About the application

Application number: 2026/91912	
What is the application for?:	Removal/variation of conditions 2 and 3 (plans) on previous permission 2023/9296
Address of the site or building:	rear of, 271, Cliffe Lane, Gomersal, Cleckheaton, BD19 4SB
Postcode:	LS11 8PG

Planning Site Layout

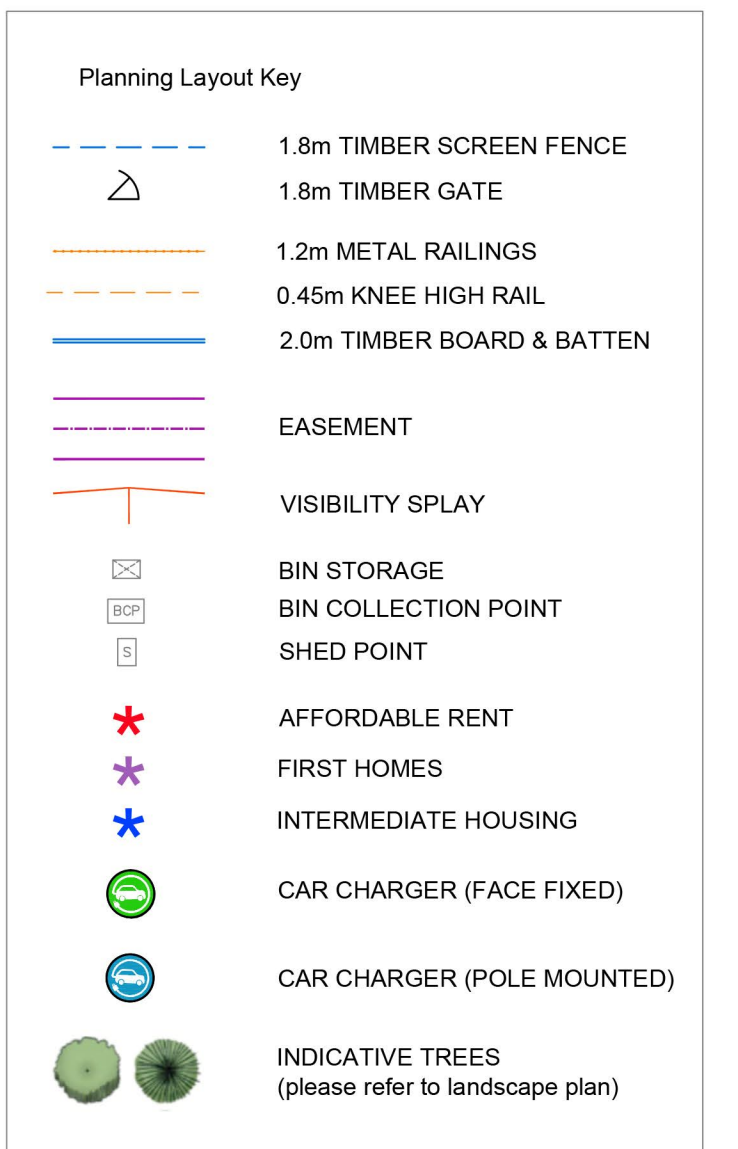
Type of comment: An objection	
Do you wish your comments to be published on the website anonymously?	Yes
My concern with this revised application is the lack of clarity with aspects of the boundary treatments of the development. On the application, I have looked at the block layout plan, id 1148971 which shows details of the different boundaries to the individual properties but there is nothing shown for details of the perimeter treatment of the site . The original similar boundary plan of the previous application: Block lay out id 10785441694-101P Site Plan Layout_A1L_1-500 COLOUR 03.03.25 submitted by the previous developer shows annotations for the north, west and eastern boundaries. These give clear instructions for the retention of trees/hedges. The boundary I am particularly concerned about is the most eastern boundary of the site, where there is a hedge adjoining the adjacent field. In the Keepmoat Design and Access statement, section 3 page 2, the plan shows annotation for the northern and western boundaries "Existing trees to boundaries to be retained" The new application shows no such annotation for the eastern boundary. The previous application, for this eastern boundary, has the following annotation next to the hedge: "existing hedge line to be retained // retaining wall to be added whilst being sympathetic to existing hedge line" This detailed plan can also be seen in Keepmoat Design and Access statements, page 2, Planning History (but not with clear annotation when enlarged). I am hoping that the proposed boundary treatment, next to the eastern perimeter hedge in the new plans, will have the same intention to retain the hedge and the fact that this annotation is not included in the new plans is merely an oversight. Another point regarding the hedge line, which may again be an oversight, is that the new plans on the eastern end show the red boundary line going straight along through the middle of the hedge. The previous plans showed the red boundary line inside the

the middle of the hedge. The previous plans showed the red boundary line inside the hedge, where a wall/fence would be.

I am hoping that all the perimeter hedges and trees, where indicated in the original plan, including the hedge at the eastern end of the site, will be protected in the new development.

It would avoid any mistakes happening at the groundworks stage of the development if there was clarification on all the new plans.
